From: Sue Howell <Sue.Howell@arun.gov.uk>
Sent: 07 June 2021 17:26
To: Planning.Responses <Planning.Responses@arun.gov.uk>
Cc: Maria Tomalova <Maria.Tomalova@arun.gov.uk>
Subject: Planning Consultation on: BN/63/21/DOC

Application ref: BN/63/21/DOC

Description: Approval of details reserved by condition imposed under BN/121/19/PL relating to conditions 3-surface water drainage, 5-landscape scheme & 7-proposed drainage scheme for surface water.

Location: Swallowfield Eastergate Lane Eastergate PO20 3SJ

Revision:	A	April 21	North boundary updated
address	Swallowfield, Eastergate Lane Eastergate, PO20 3SJ		
project	Proposed construction of detached chalet bungalow		
title	Proposed Soft and Hard Landscaping		
scale	1:200 @A3	date	April 2021
dwg no.	2019.257Land	revision	A

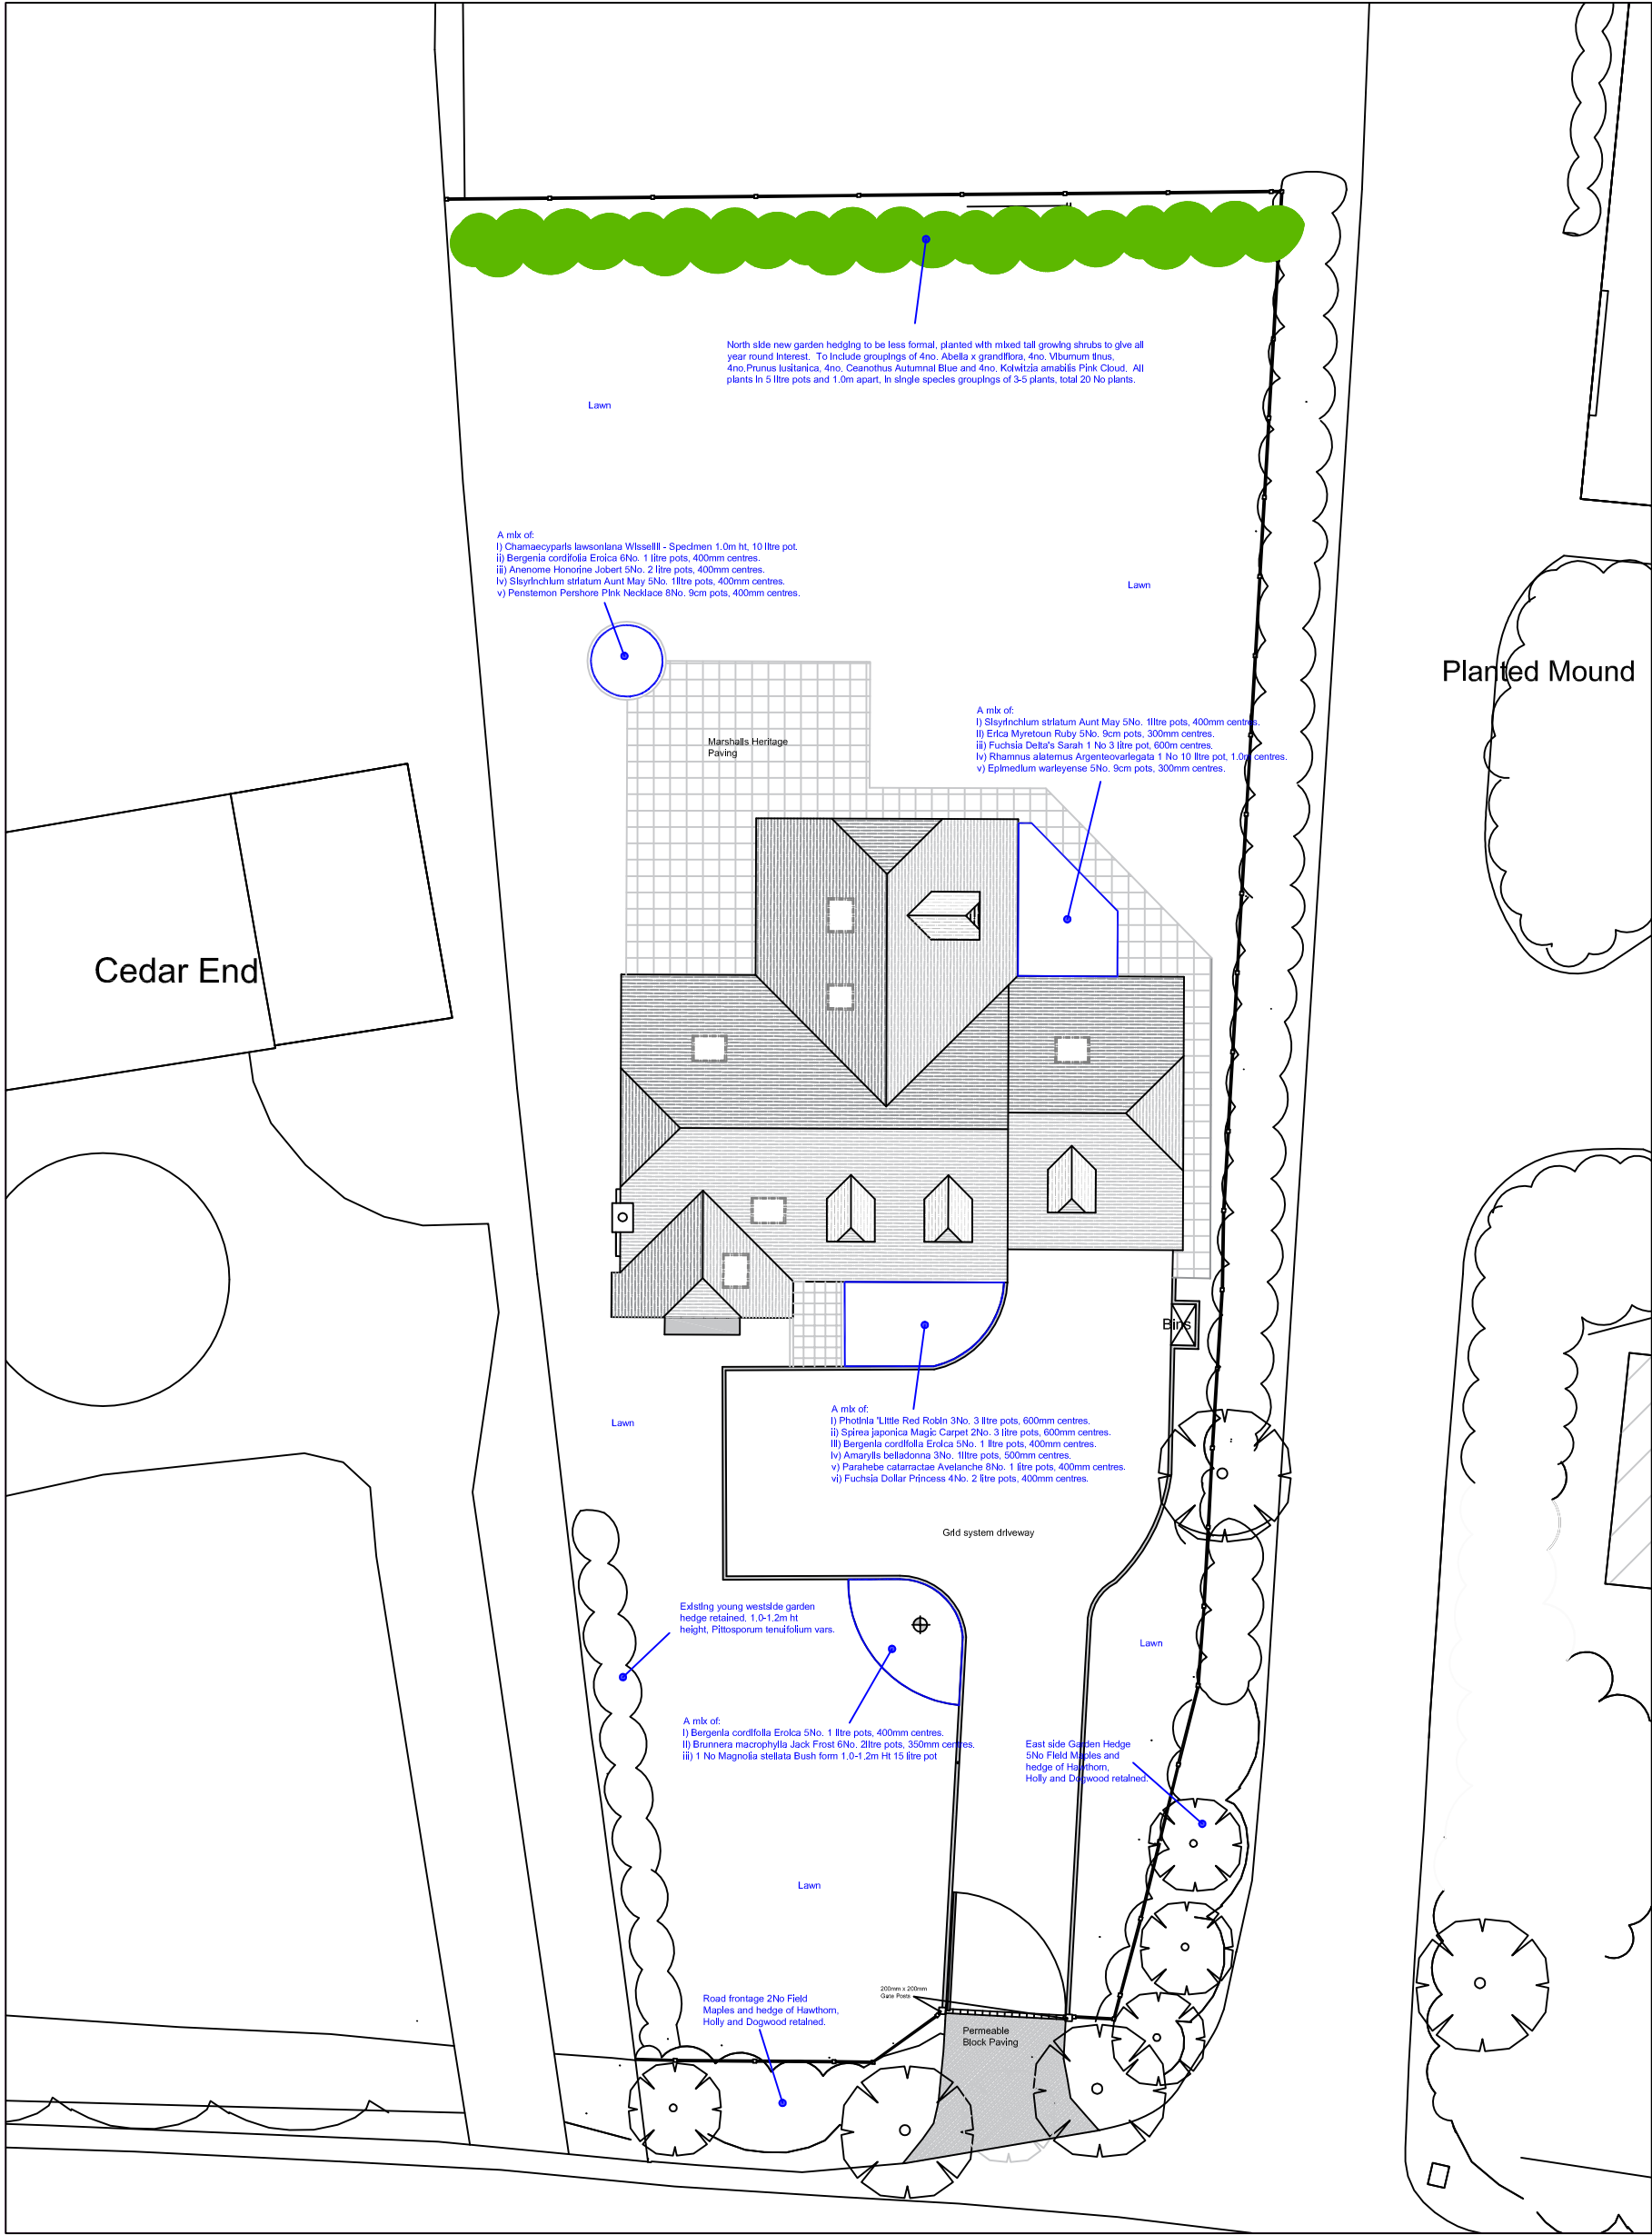
The proposed landscape detail specified in proposed soft and hard landscaping dwg 2019.257 LAND Rev A has proposed a scheme which would be fitting for location and contains detail including species choice, quantities being proposed, planting densities and size at time of planting.

The scheme would be fitting for location and when maintained to establishment would provide a softening to the proposals and aid in biodiversity habitat formation and net gain.

Recommend the discharge of Condition 5 Landscaping scheme on this application BN/63/21/DOC imposed under BN/121/19/PL
